Re: Sydney Metro Crows Nest Over Station Development (SSD 9579)

Northern Sydney Local Health District wishes to make the following comments in respect to the Noise and vibration impact report (NVR).

Figure 12: Predicted podium construction noise levels

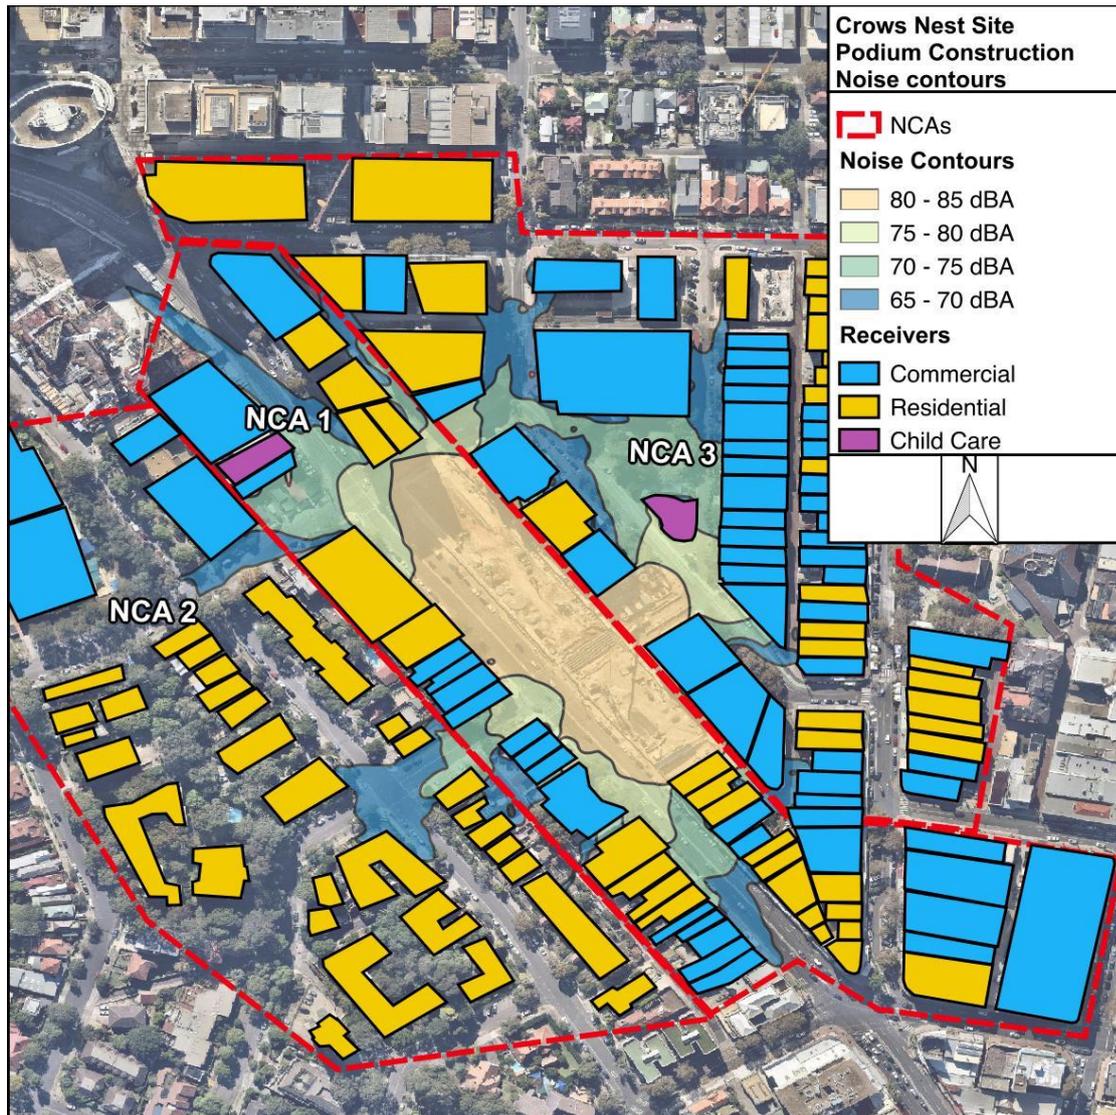
The NVR indicates that construction noise will exceed the NSW Interim Construction Guideline (ICG 2009) daytime Noise Management Level (NML) at sensitive noise receivers in all noise catchment areas. In particular, residential properties adjacent to the site and two childcare centres (Froebel St Leonards Early Learning Centre, 454-456 Pacific Highway, and Kelly's Place Children's Centre, cnr Clarke and Hume Streets, which has an outdoor play area) will experience significant noise impacts resulting from noise levels that are predicted to exceed NMLs by up to 25 decibels.

Accordingly, it is recommended that the proponent employs feasible and reasonable noise mitigation measures in regard to work practices and construction activities to ensure that the required NMLs are met at all receivers. In view of the significant noise exceedances predicted at Froebel St Leonards Early Learning Centre, Kelly's Place Children's Centre (which has an outdoor play area) and adjacent residential receivers, it is recommended that the proponent engages with these businesses and property owners to implement appropriate noise mitigation measures.
